CITY OF ALBUQUERQUE

December 10, 2021

La Vida Llena, Phase 3
10501 Lagrima De Oro Rd NE
Request for Certificate of Occupancy
Transportation Development Final Inspection
Engineer's/Architect's Stamp dated 10-30-19(DRB) (F21D028)
Certification dated 11-22-21

A1 ENLARGED SITE PLAN
1" = 20'-0"

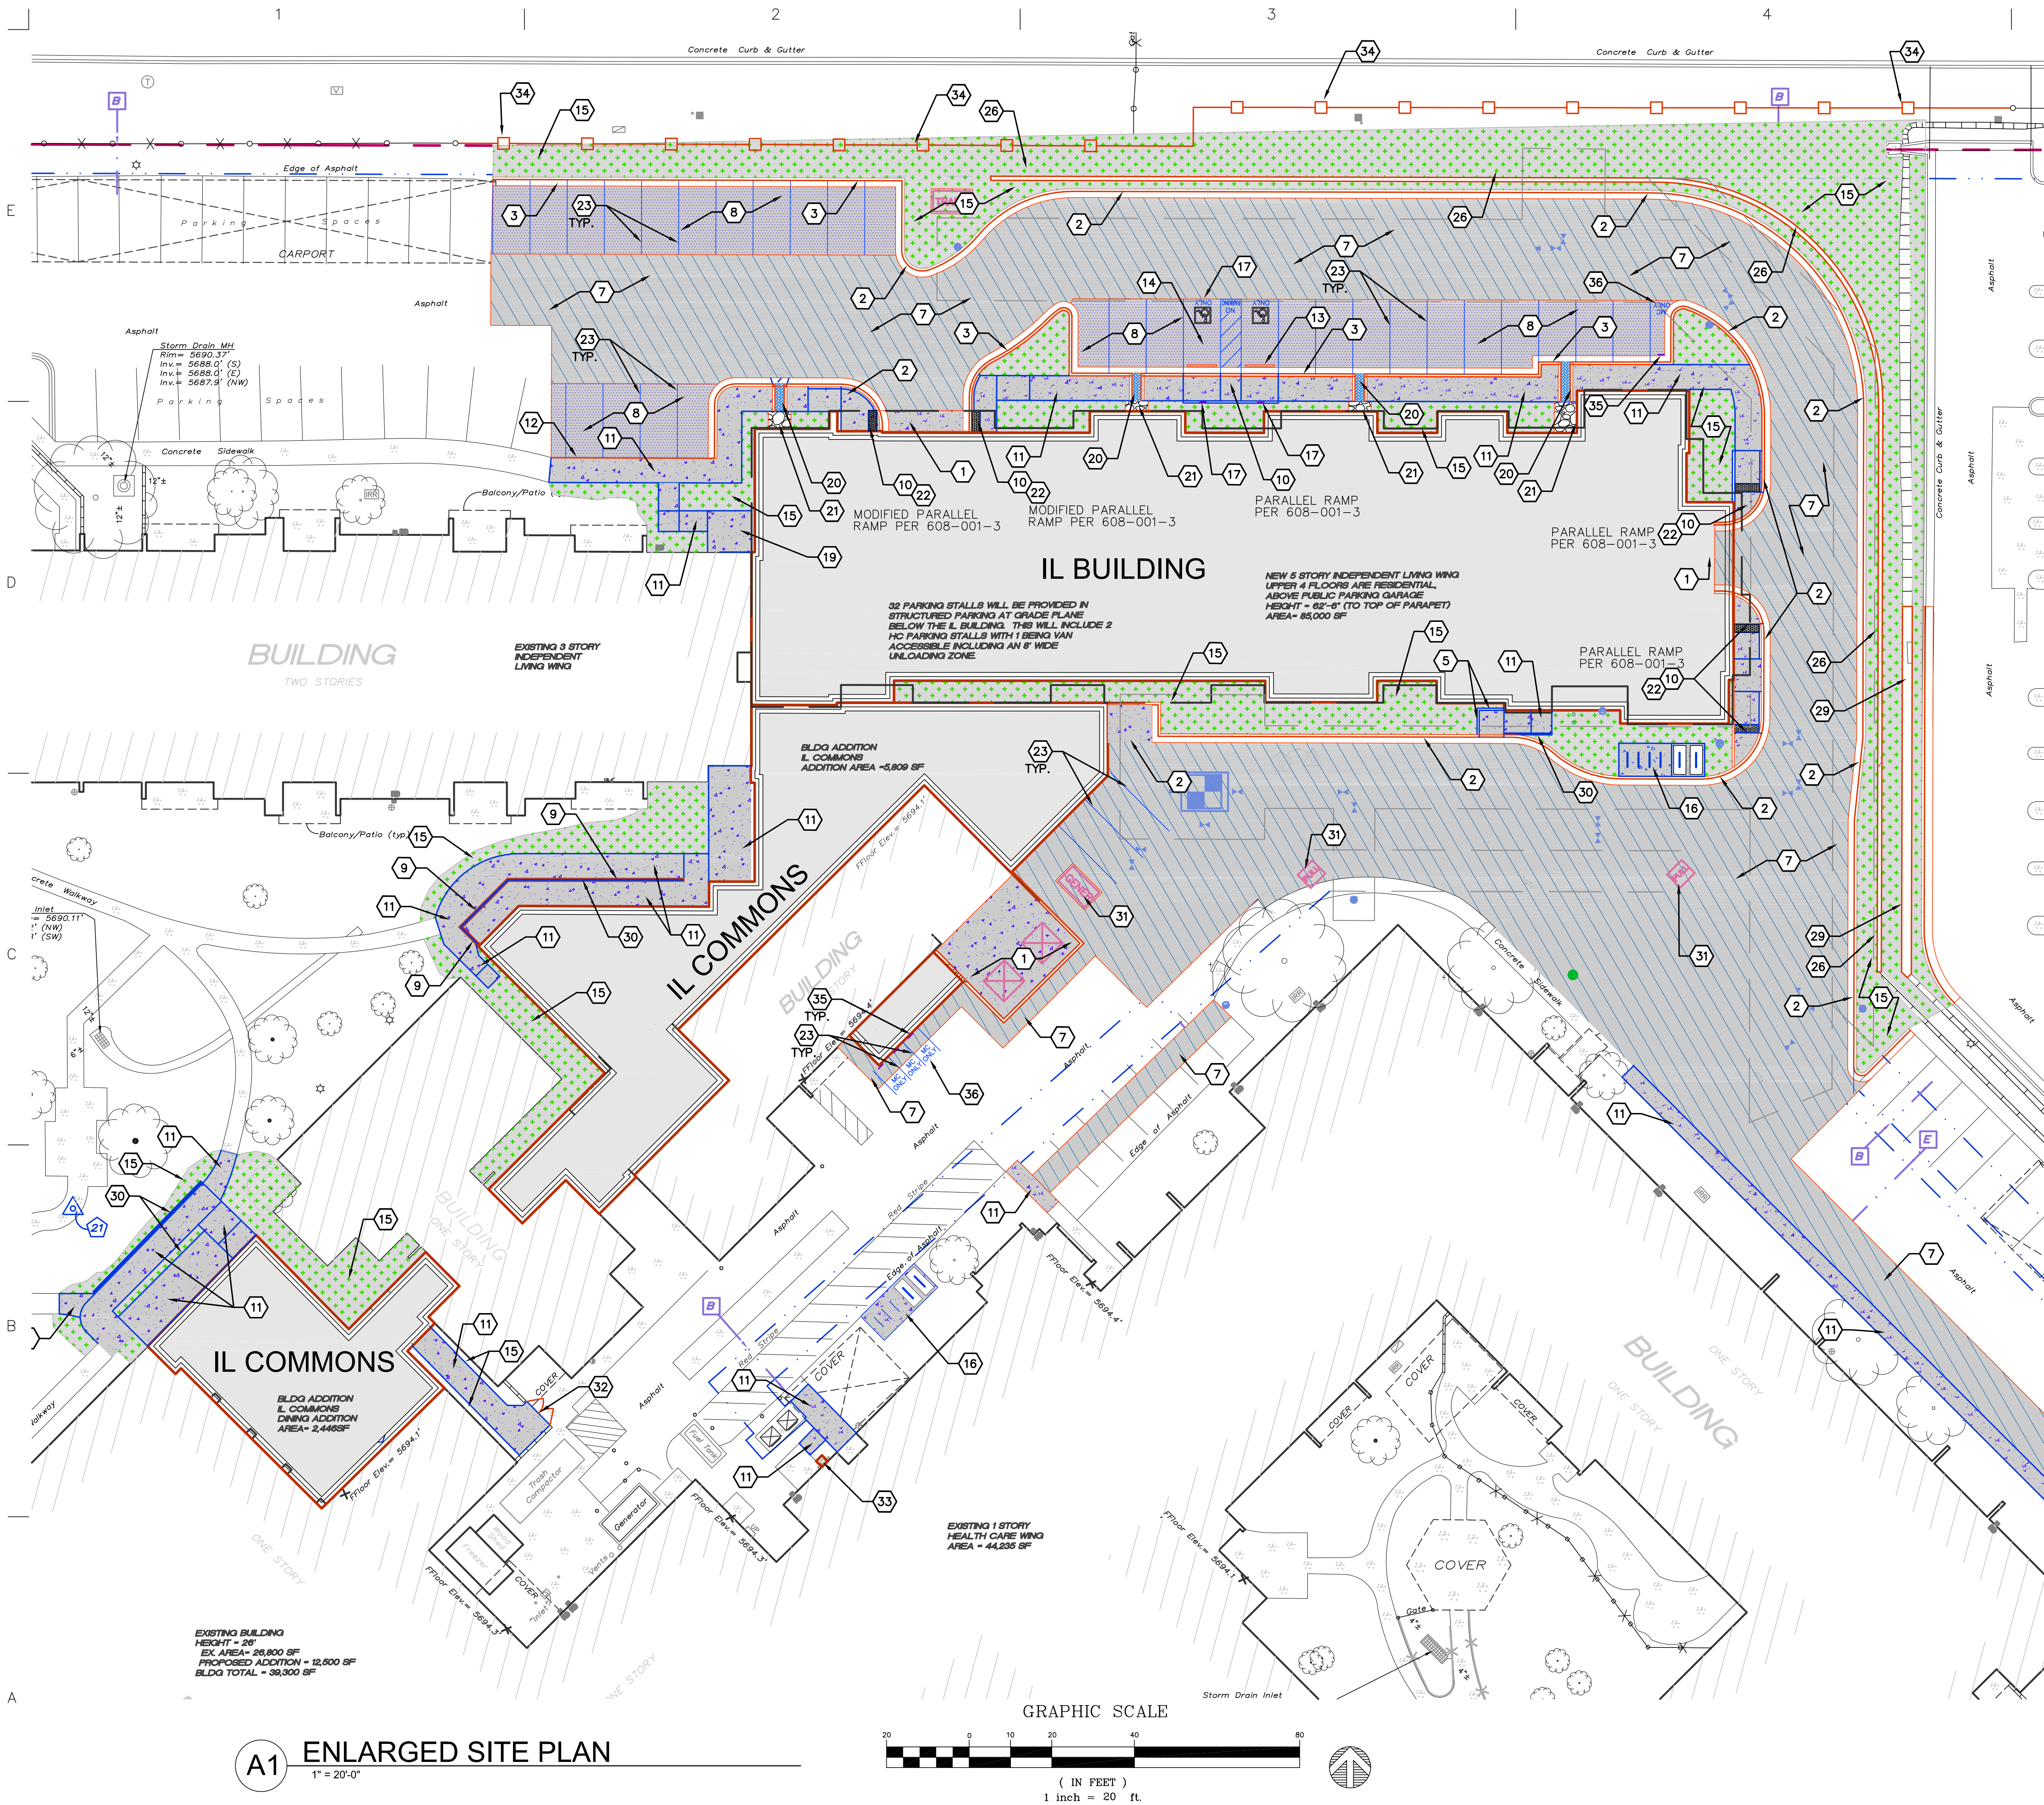
- Please redline plan to reflect the motorcycle parking relocation.
- Add "COMPACT" to the parking stalls 15 foot in length
- Remove construction equipment, materials, porta potties, security fence and debris from site for release of Final CO.
- Please shave all ADA ramp lips.
